EL PASO COUNTY GRADING AND EROSION CONTROL PLAN CHECKLIST

PPR-22-059

SHEET IDENTIFICATION EC2

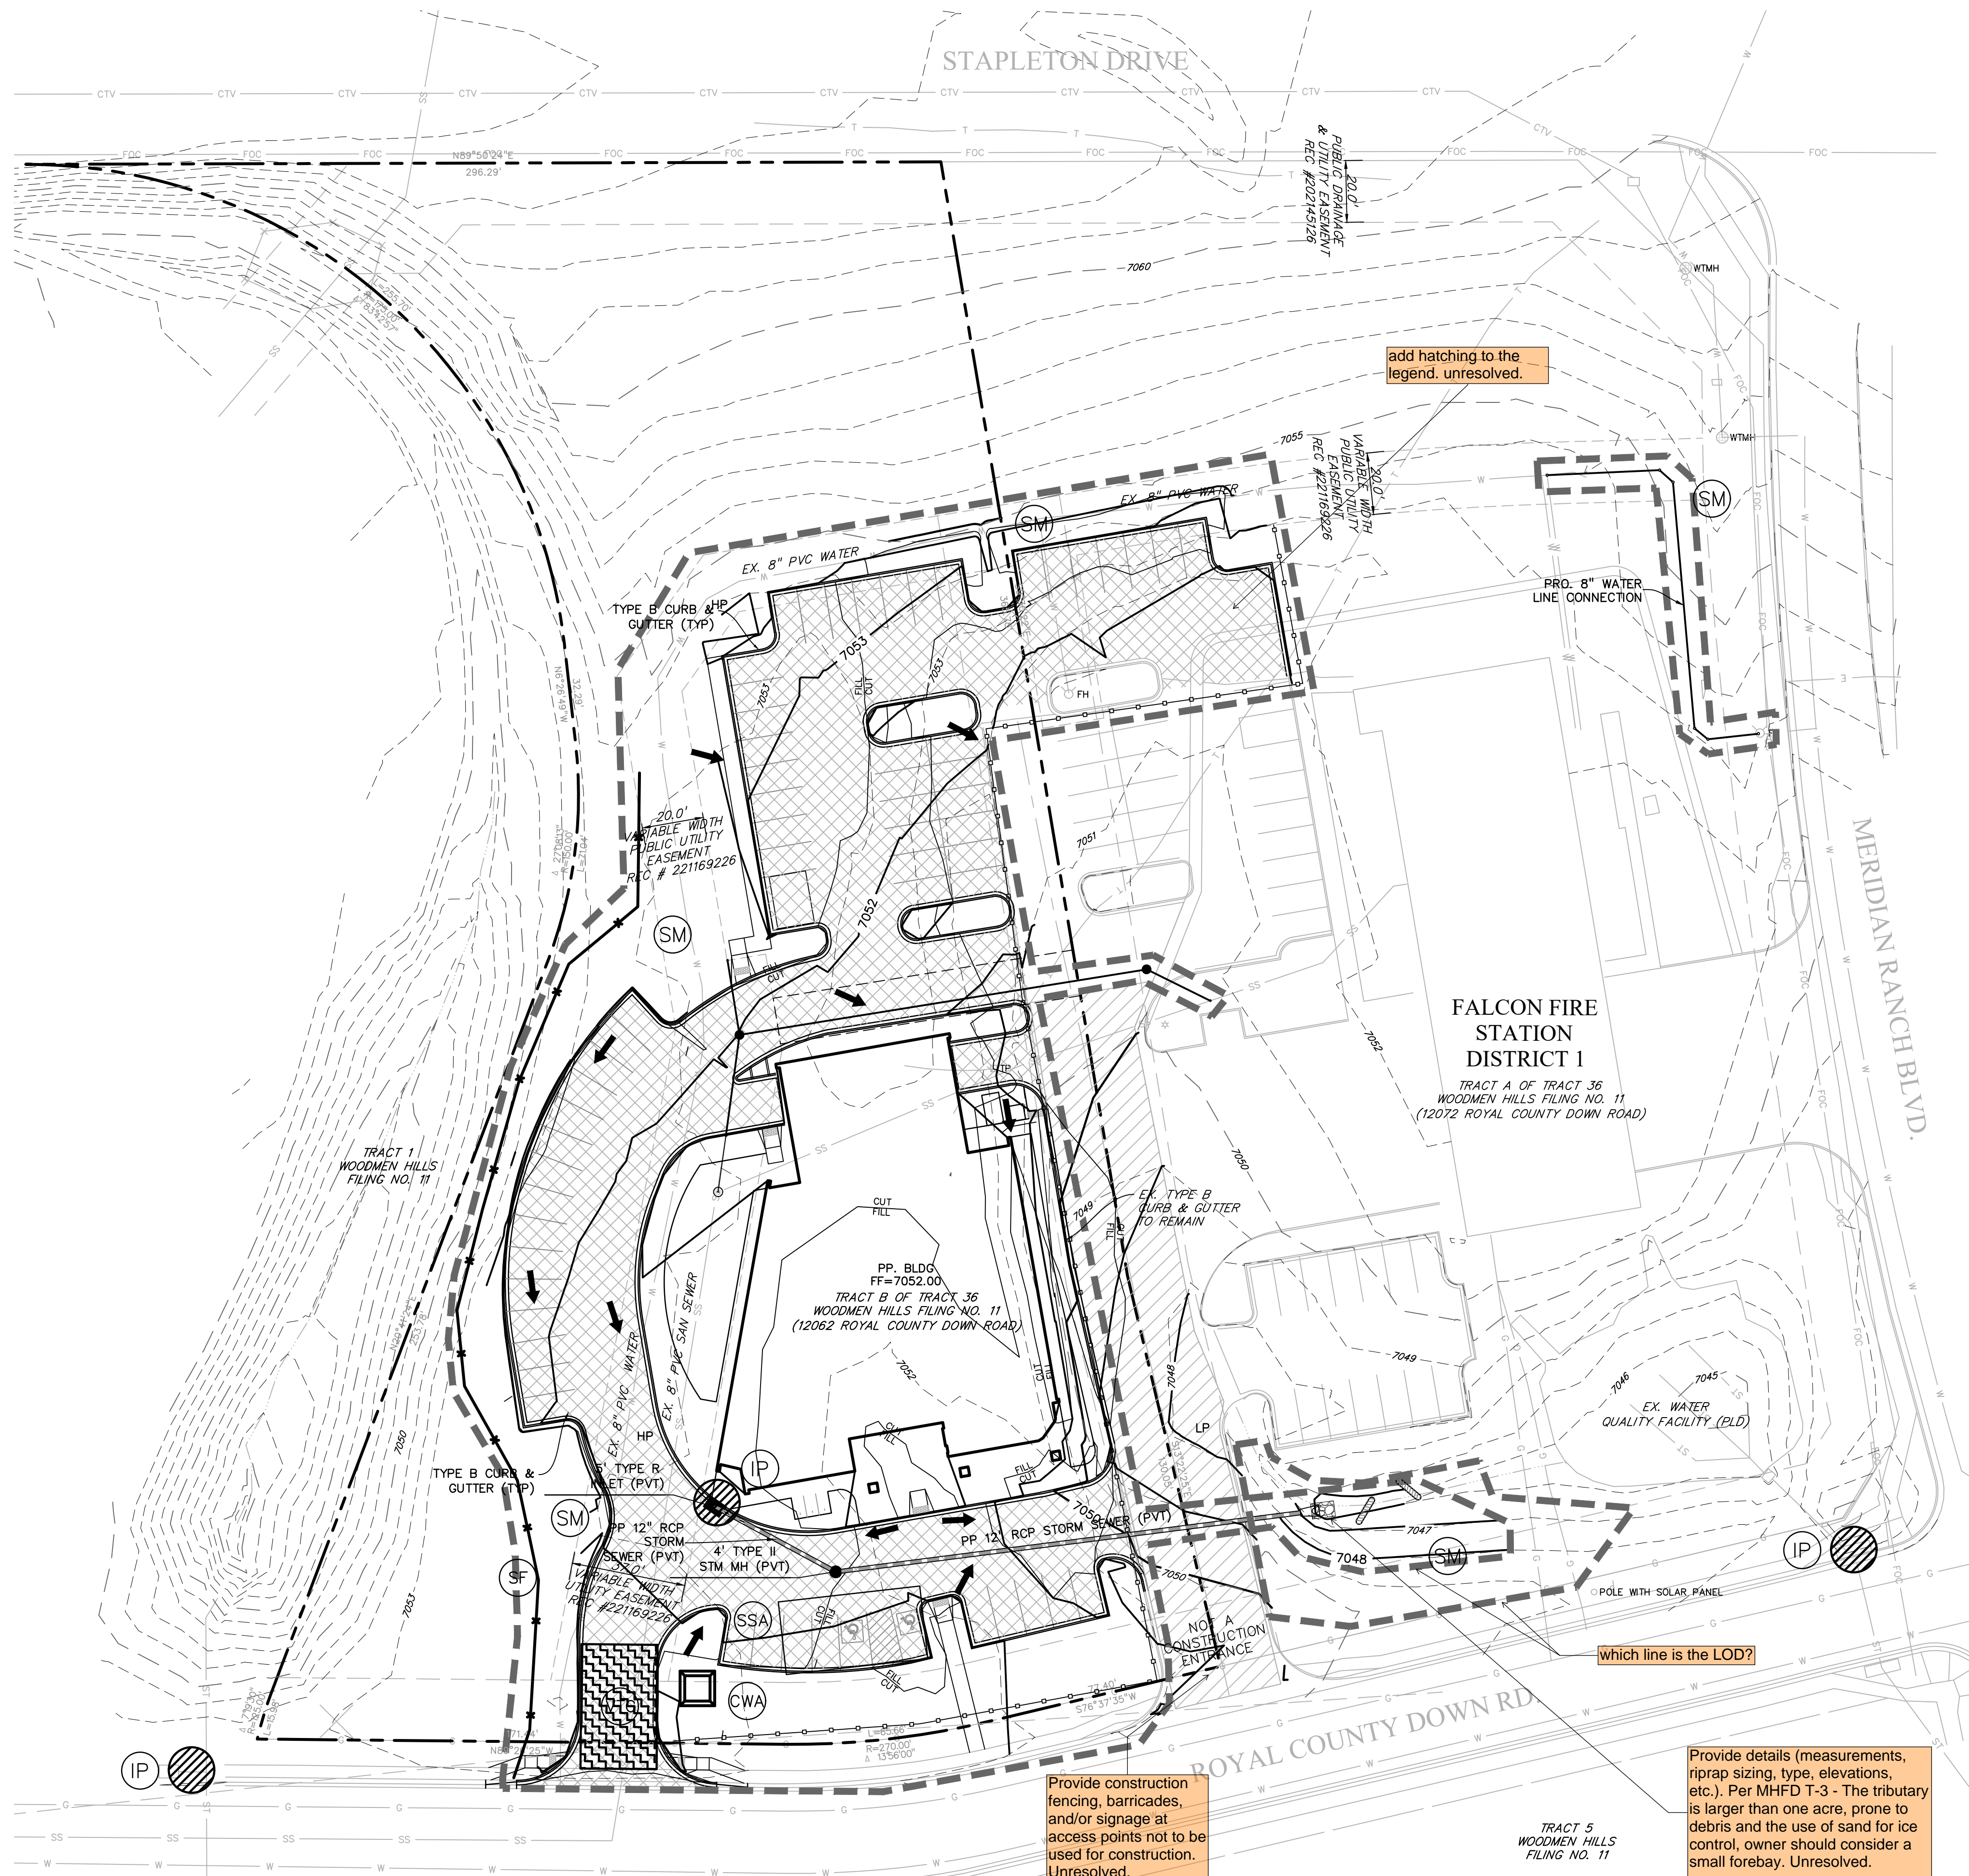
w	Vehicle tracking provided at all construction entrances/exits. Construction fencing, barricades, and/or signage provided at access points not to be used for construction		✗
x	Temporary sediment ponds provided for disturbed drainage areas greater than 1 acre		✗
